Subject: FW: Response To Application Number 24/0349/HH at 3 Martin Avenue Kirby Muxloe Leicester Leicestershire LE9 2JH

Transport Planner, Highway Development Management

Proposed Site Plan

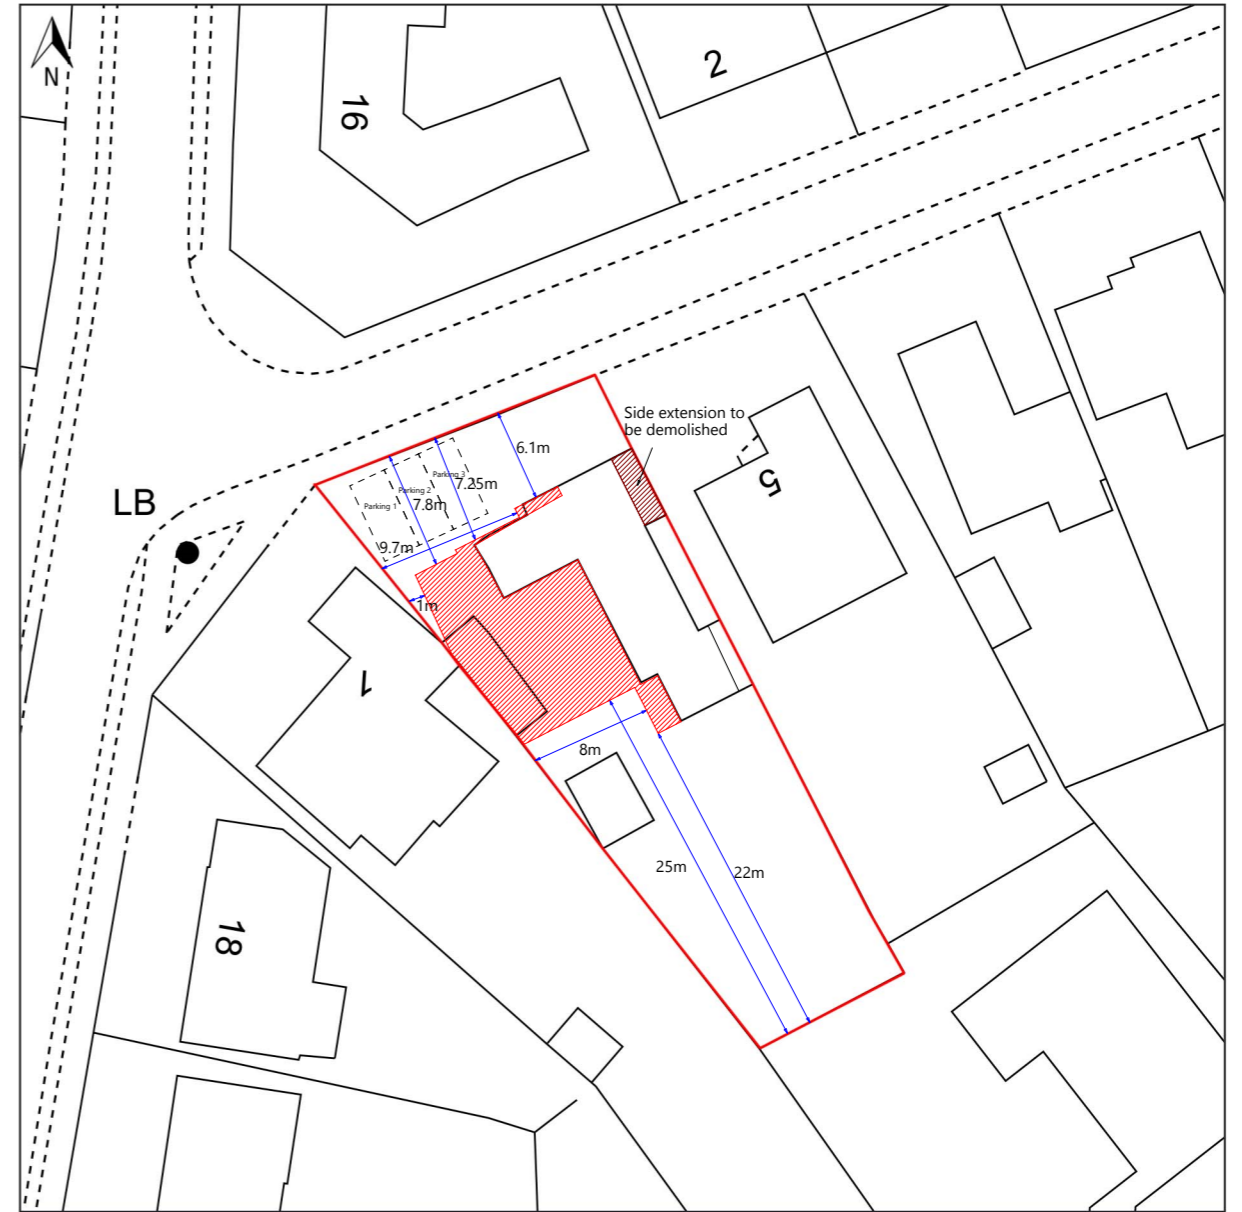
As the Applicant is proposing to extend the dropped kerb away from the junction, there should not be a risk of conflict with turning vehicles. However, it does not appear that the dropped kerbs, as shown on 'The Practical Planning Company' drawing number D301 Revision A, would be sufficient in length to cater for all parking spaces. It is therefore likely that, in any forthcoming vehicular access application, additional dropped kerbs would be required to serve all three parking spaces.

I have just received an updated parking plan though (just uploaded it) ..showing a proposed dropped kerb and hardstanding..are you satisfied that the dropped kerb in that location will be acceptable and that the cars can access and egress?

Irrespective of planning permission, the Applicant would need to apply to Leicestershire County Council to create a new vehicular access onto the adopted highway network. Further information on this is contained within the Vehicular Access (Dropped Kerbs) Information Pack - <https://www.leicestershire.gov.uk/sites/default/files/2023-02/VA1-Information-Pack.pdf> . As you are aware, any grant of planning permission does not guarantee that a vehicular access application would be successful.
